NSW GOVERNMENT
Department of Planning

Major Project Request – Mixed use development (MP08_0244)

Lot A in DP 418891, Lot 11 in DP 713206, Lots 101, 102 and 103 in DP 1067930 and Lot 3 in DP 713505 – 23, 23A, 27 – 37 Lindfield Avenue and 11 Havilah Lane, Lindfield.

5 CONCEPT MASSING ELEVATION  
1:200

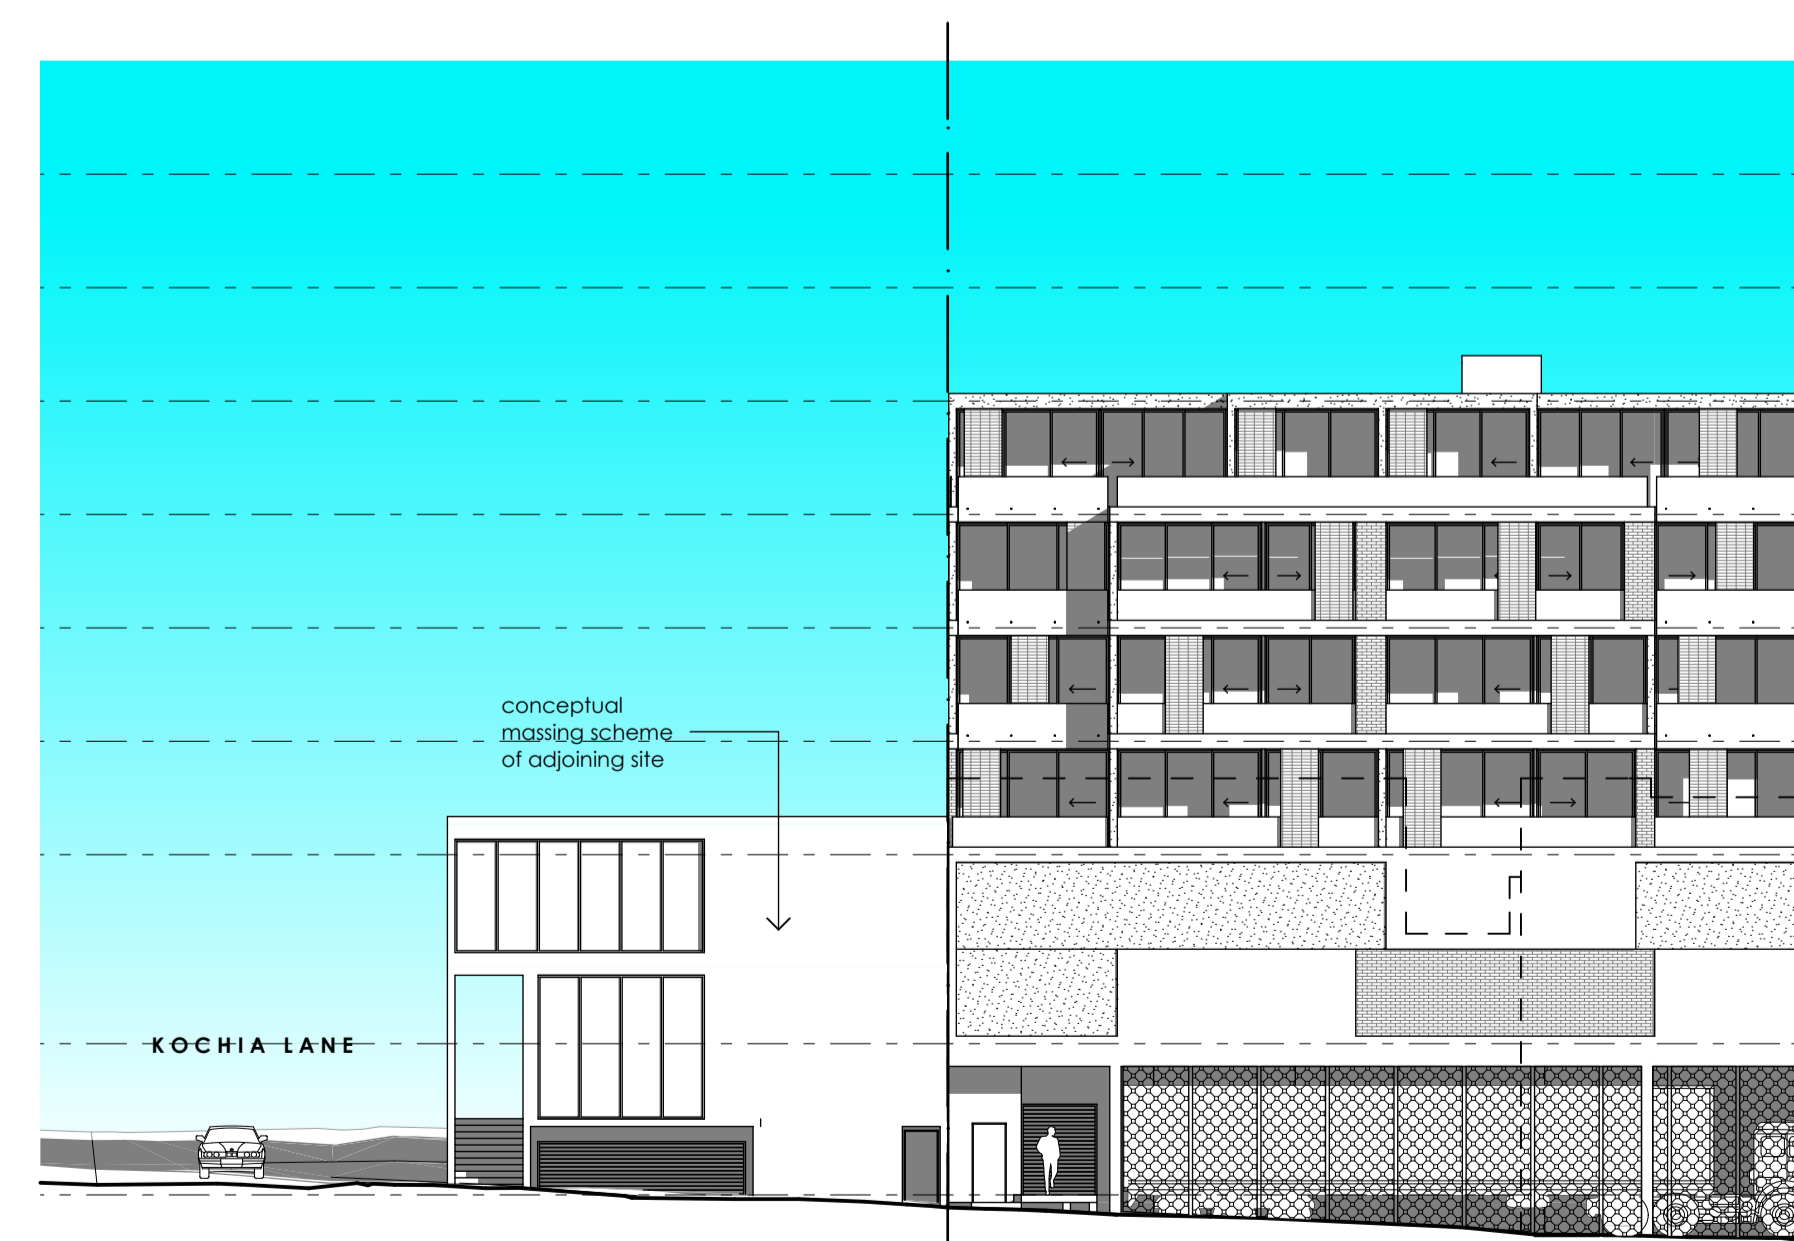
The Department has concern regarding isolation of 2 Kochia Lane in the eastern corner of Site 4. The design should ensure any future development on the site is not compromised by the exclusion of this site.
